13 January 2017

File No: D/2014/17/F
Our Ref: 2017/601713

SSD 5824 MOD 3 and MOD 4 – One Carrington Street Redevelopment

Photo: Carrington Street elevation with original door opening in centre of picture

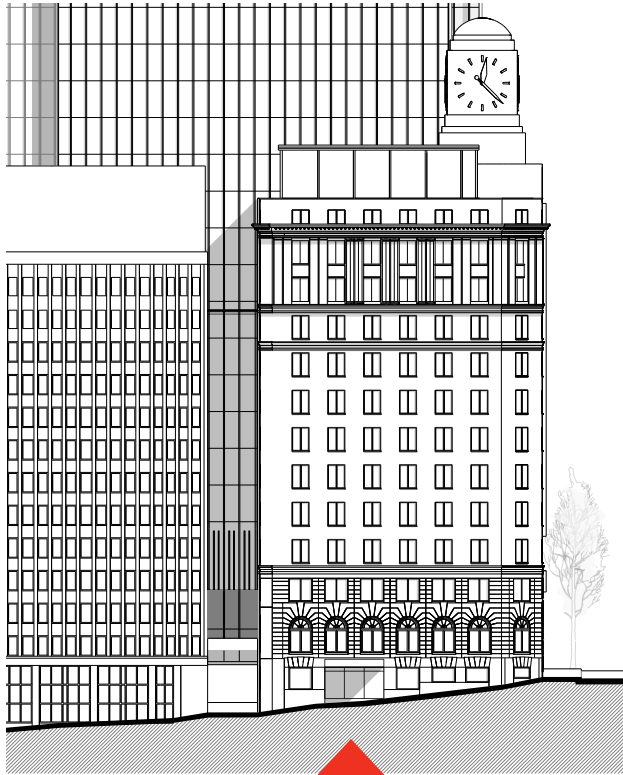
The proposed removal of three original steel framed windows with arched top panes, and trachyte voussoirs between, all dating from 1938 to create the new door openings into the lobby is not supported despite the details submitted on the 20th December 2016 below. The details, included below, have further convinced the City that the lowering of the three window openings would have a highly adverse impact upon the heritage significance of the building.

The removal of the steel windows assemblies and the demotion of the wedge shaped trachyte voussoirs that form the base of the building to form door openings will result in the loss of significant fabric and intricate architectural detailing; in addition to the loss of character and loss of character by eroding the strong base of the palazzo design of the building. These elements are key detail elements of the original Spain and Cosh design. The wedge shaped trachyte voussoirs of the base give emphasis to the voussoirs of the faience semicircular arches above and are architecturally mutually dependent. Further, the proportions of the proposed doors are overly vertical and are not representative of the proportions of the façade. The symmetry and balance of the façade is not restored as claimed by the Design Report. It is considered that the opposite results occurs, the façade at the lower levels of the building, becomes asymmetrical in its composition.

The most southern of the openings in the Carrington Street façade, pictured below, has been previously cut down as a doorway. This clearly shows the visual impact when compared with the image of an intact opening, further below.

In conclusion we do not support the proposed lowering of the Carrington Street windows to form doors. The levels of the ground floor, both in Shell House and the

Figure 5 | Approved Carrington Street entry (left) and proposed Carrington Street entry (right)
(Source: Applicant's Modification Report)

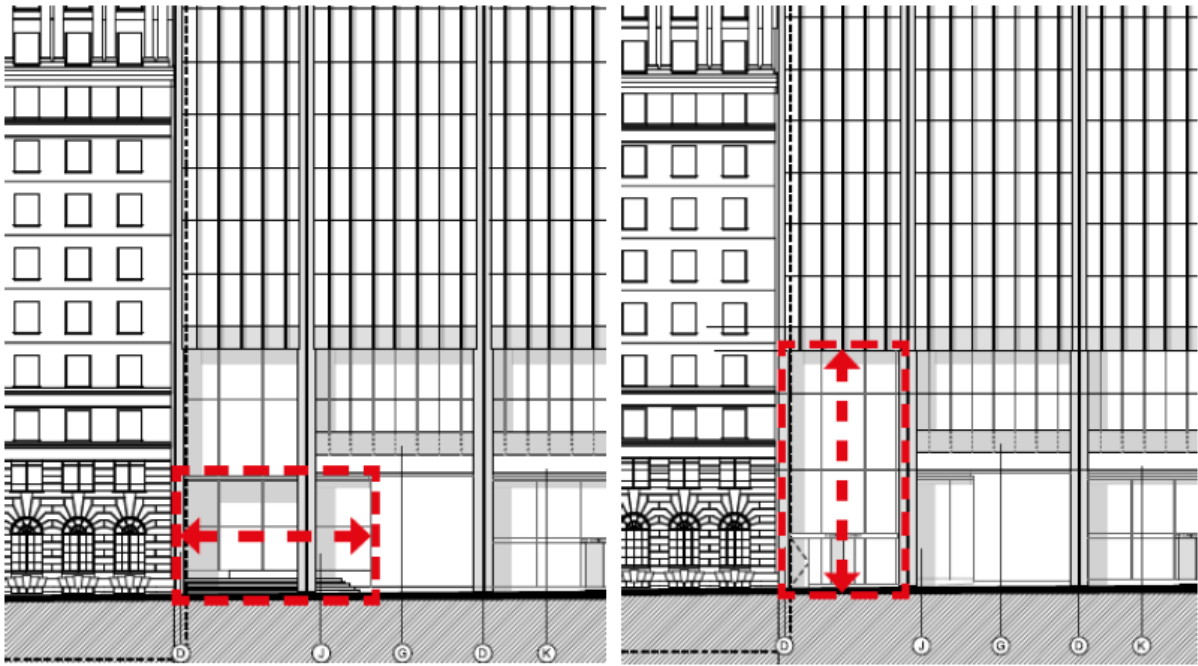
Further, the City does not support the visual intrusion of the revolving doors behind the original openings. These will further erode the character of the building.
